**Northrop JN: 222337**

7 February 2024

**Re: Calala BESS: SSD 52786213**  
 Response to submission regarding Water Management

This response represents an Addendum to the previously submitted report by Northrop titled: *Water Management Plan: Calala Battery Energy Storage System (Rev C, dated 24.07.23)*

Figure E: Riparian Zones near the site

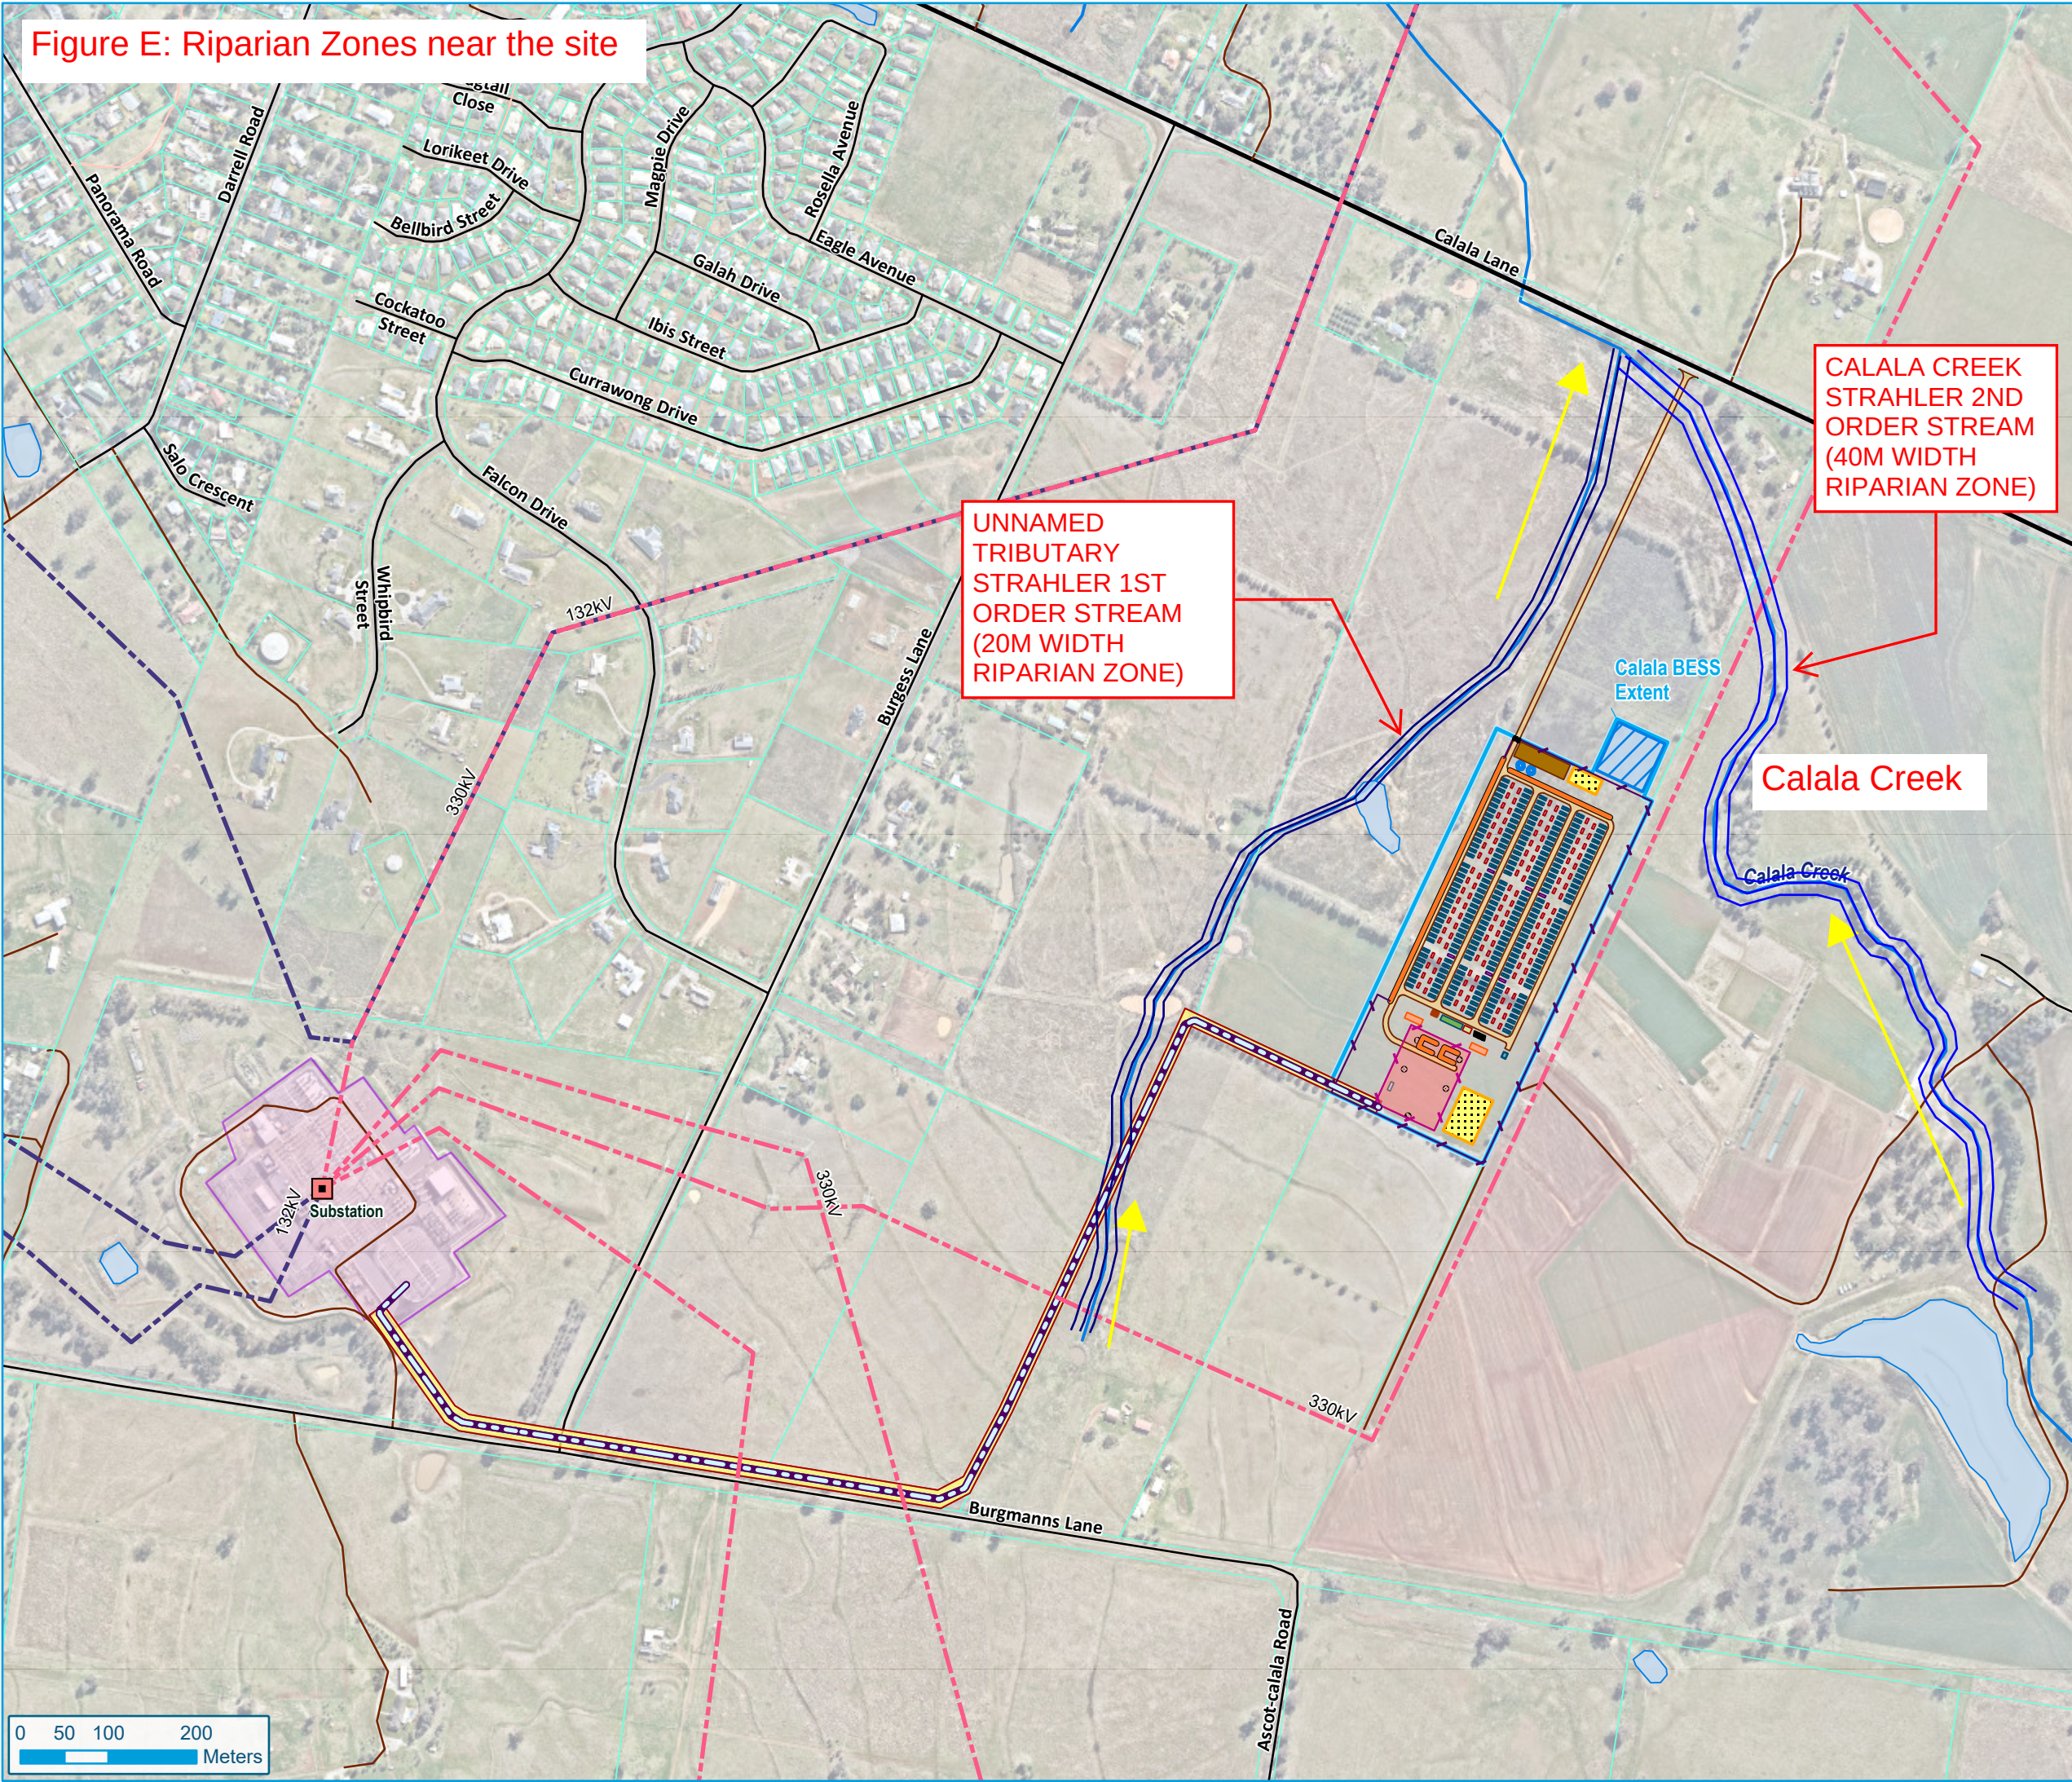
Submission comment	Response
<p>2.0 Controlled activities on waterfront land</p> <p>2.1 Recommendation – prior to determination</p> <p>The proponent should review works proposed within waterfront land (40m of a watercourse) to demonstrate consistency with the Guidelines for Controlled Activities on Waterfront Land.</p> <p>Explanation: The Water Management Report for the project states that once the project is approved, the stamped plans will need to be submitted as part of a Controlled Activity Approval application to DPE-Water. This is not supported because the impact of works on waterfront land needs to be considered as part the project’s SSD assessment.</p> <p>If approved, the project will be exempt from the need to acquire a Controlled Activity Approval from DPE-Water under Section 4.41(1)(g) of Environmental Planning and Assessment Act 1979. However, for the exemption to apply to the Project, the proponent needs to consider the Guidelines for Controlled Activities on Waterfront Land for all works that occur on waterfront land (including minor watercourses), prior to determination.</p>	<p>With thanks for advising of the exemption for Controlled Activity approval.</p> <p>There are two instances/locations where the works will intersect waterfront land, as follows:</p> <ol style="list-style-type: none"> <li>1. The stabilised swale outlet from the proposed sediment pond/wet basin will flow through the riparian zone into Calala Creek (this was not shown on the Drawings provided in the EIS submission, but is shown indicatively below)</li> </ol>  <ol style="list-style-type: none"> <li>2. The permanent access road crosses the riparian zone and channel of Calala Creek (this was shown on the Civil Drawings by Sky Engineering).</li> </ol>  <p>At the two locations where the works intersect the creek riparian zone, there are two Guidelines that are relevant to the assessment, viz.:</p> <ol style="list-style-type: none"> <li>1. Outlet structures – for the swale to discharge into Calala Creek, and</li> <li>2. Watercourse crossings – for the access road crossing over Calala Creek</li> </ol> <p>The <b>assessment of the both the Outlet Structure and the Watercourse Crossing</b> in relation to the Guidelines is provided in <b>Attachment 4</b>.</p>
